### SUBMISSION: WOOLGOOLGA TO BALLINA PACIFIC HWY UPGRADE- SSI-4963

I support the project in the main but wish to register my concern re:- Position reference No 13, Section 5

Figure 13-5: Heritage items within or near the project boundary: Section 5

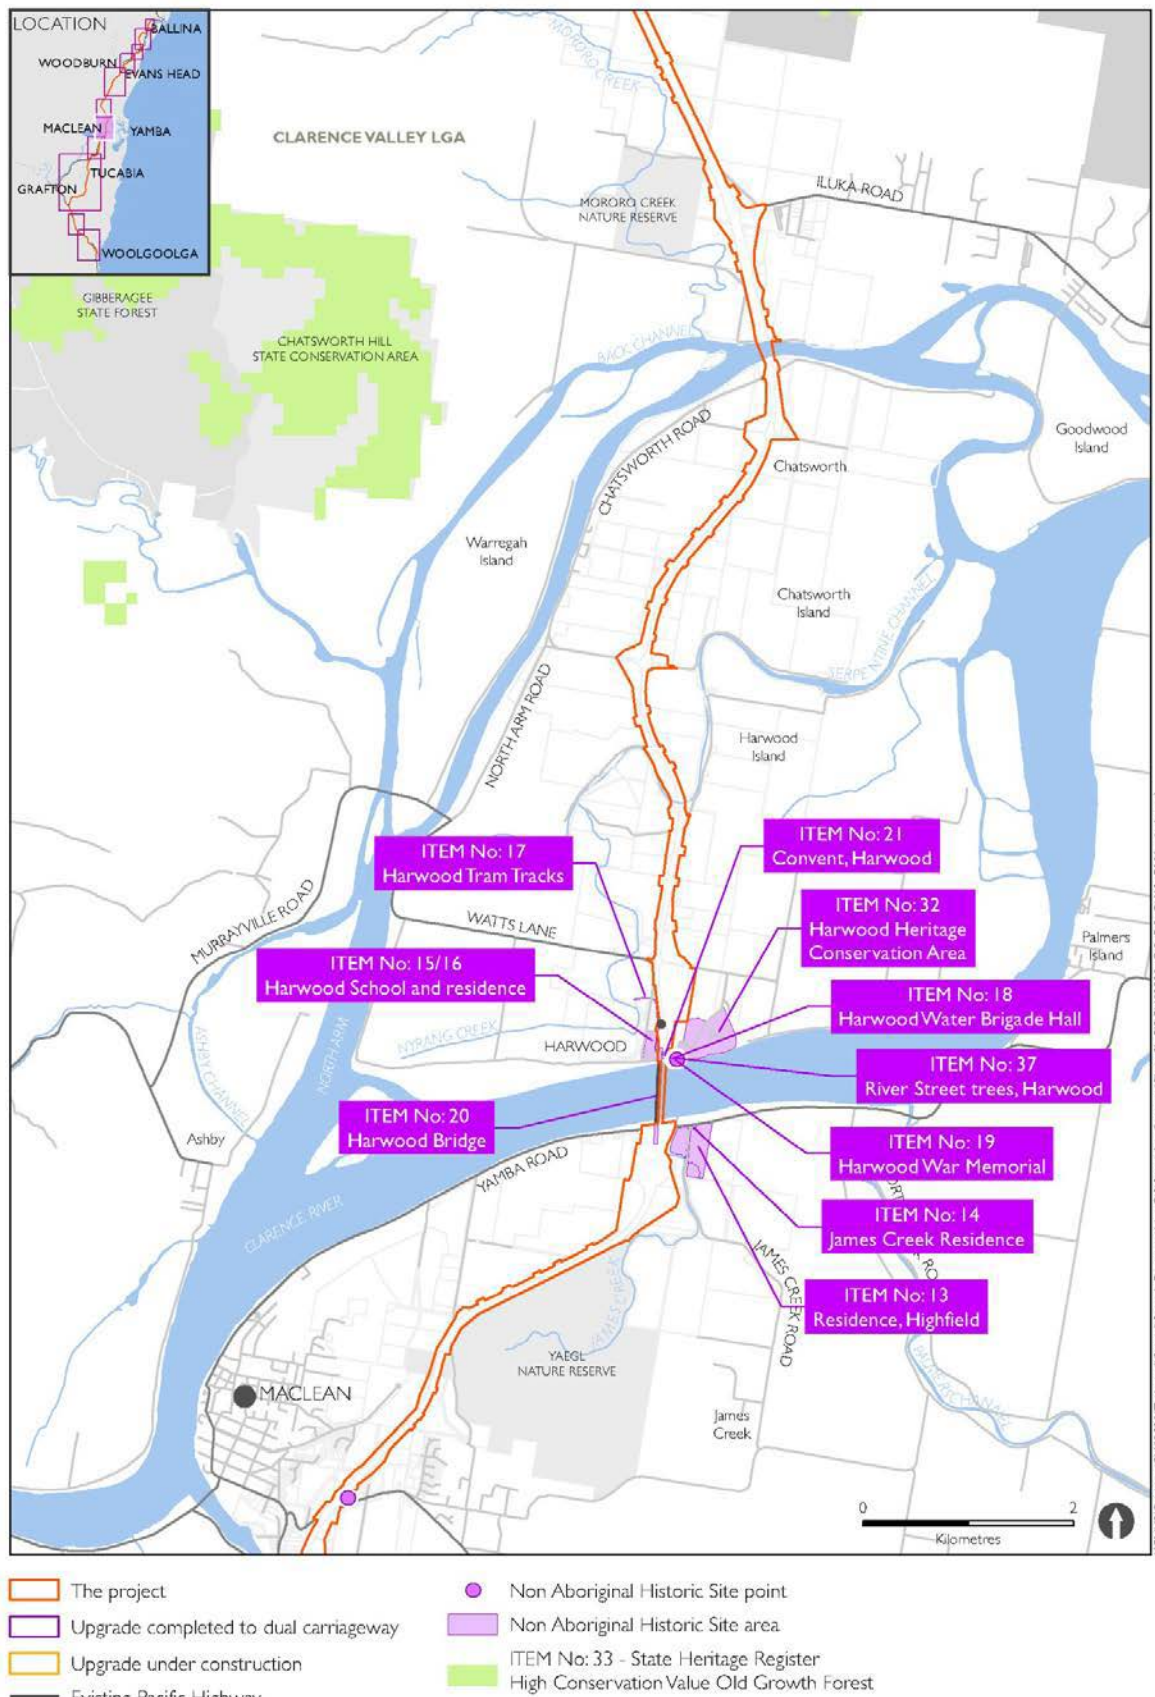
I am concerned about our heritage home, started 1917, finished 1920 (No 13 in Section 5 Pages 70 and 271 of 390 in the Historical Non Aboriginal Heritage Document FINAL) The house is built of bricks using lime mortar and is plaster lined.

As we know from renovations in the past, the bricks and plaster are delicate and could be subject to damage by vibration.

The house is on a hill overlooking the existing bridge and on the same geological layer that dips down under the highway road. We have recently felt the house shake during road works on the clover leaves, particularly vibrating rollers.

The EIS and Final document states that we will not be subjected to vibration problems, but I wish to register my concerns that it may.
